From: Remway Design - Jason Wilson [jason@remwaydesign.co.uk]
Sent: 06 December 2011 10:09
To: Crew, Chris
Cc: _planningadvice
Subject: RE: H16-0915-11 - Condition compliance, Land adj. 45 Albert St, Spalding

From: Crew, Chris [mailto:ccrew@sholland.gov.uk]
Sent: Monday, December 05, 2011 12:00 PM
To: Remway Design - Jason Wilson
Cc: _planningadvice
Subject: H16-0915-11 - Condition compliance, Land adj. 45 Albert St, Spalding

A3- 1605 - 02 "E"

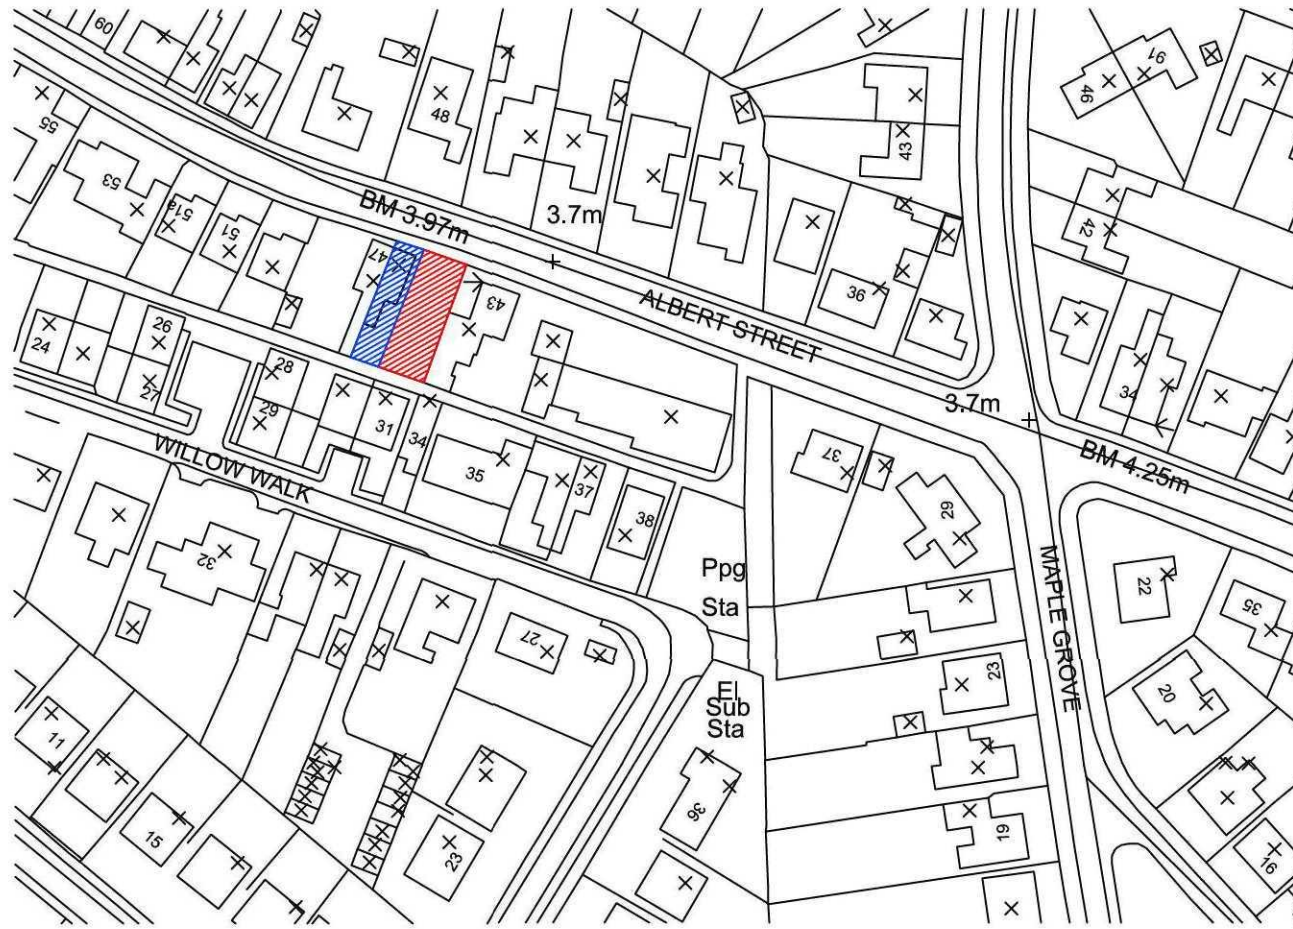
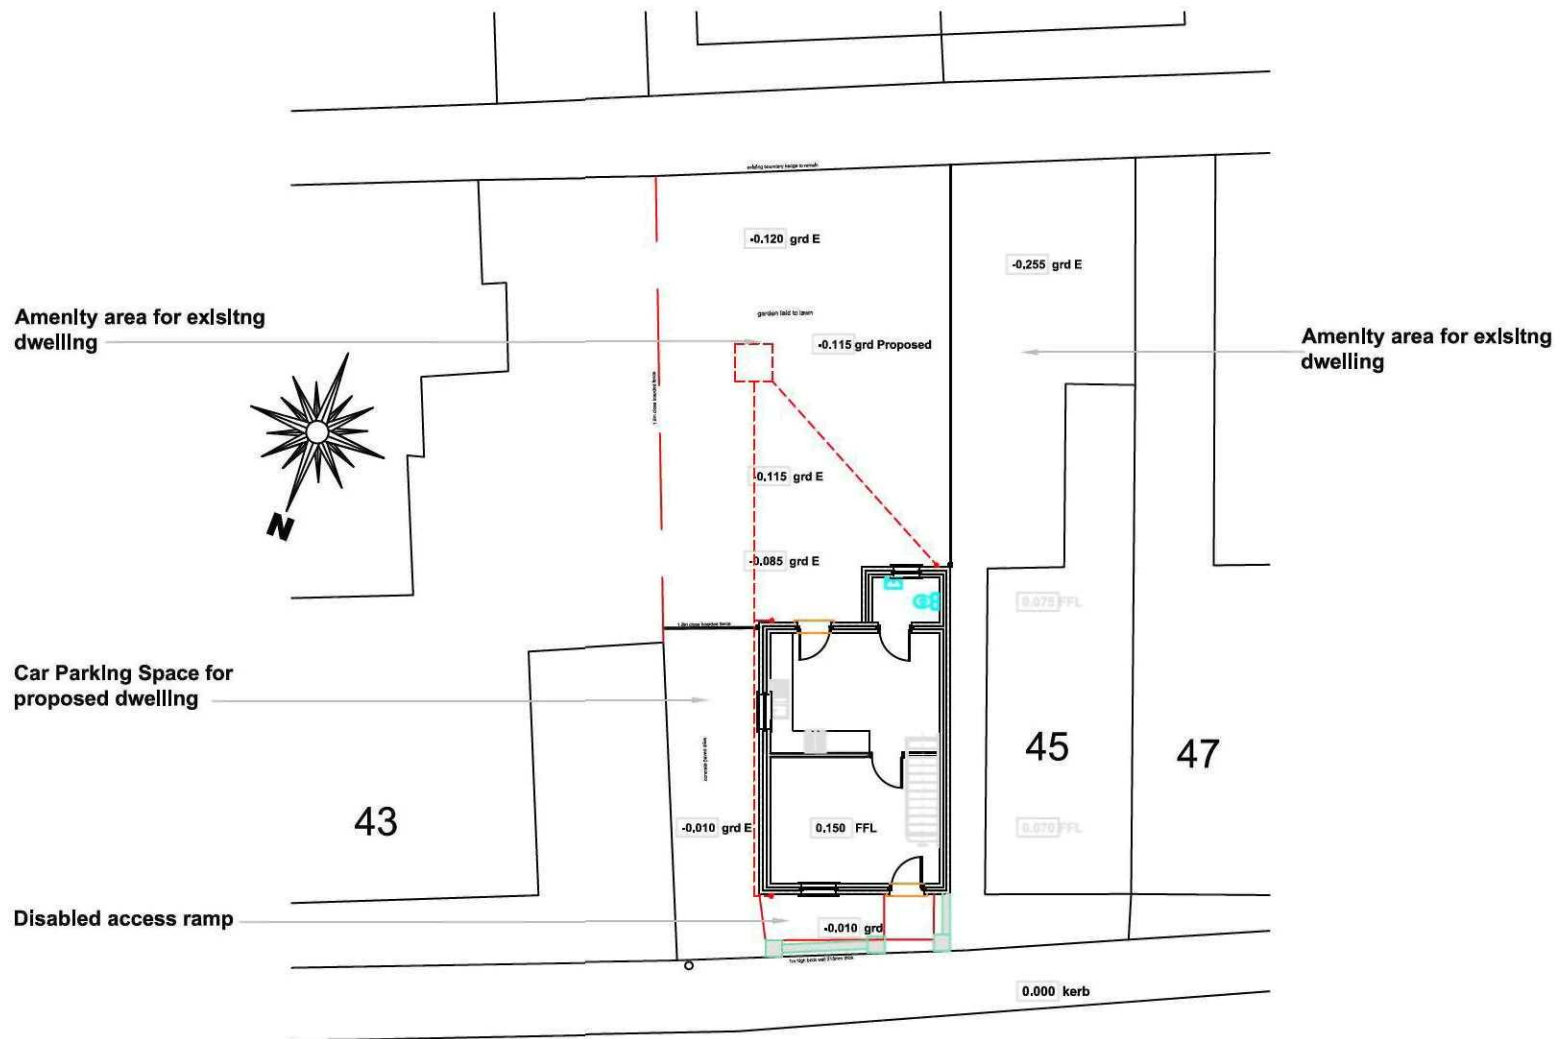
Further to the above referenced application, the notes on the drawing apparently relating to walls/fences are illegible due to the size of the text. Can you please clarify what is proposed?

rev "F" - 05.12.11 - Text height Increased
rev "E" - 22.11.11 - Condition Compliance Details added
rev "D" - 09.06.10 - Site Boundary Amended
rev "C" - 17.03.09 - Building Control Amendments
rev "B" - 02.12.08 - Site Location boundary amended
rev "A" - 11.11.08 - Layout amended to suit the Planning Dept.
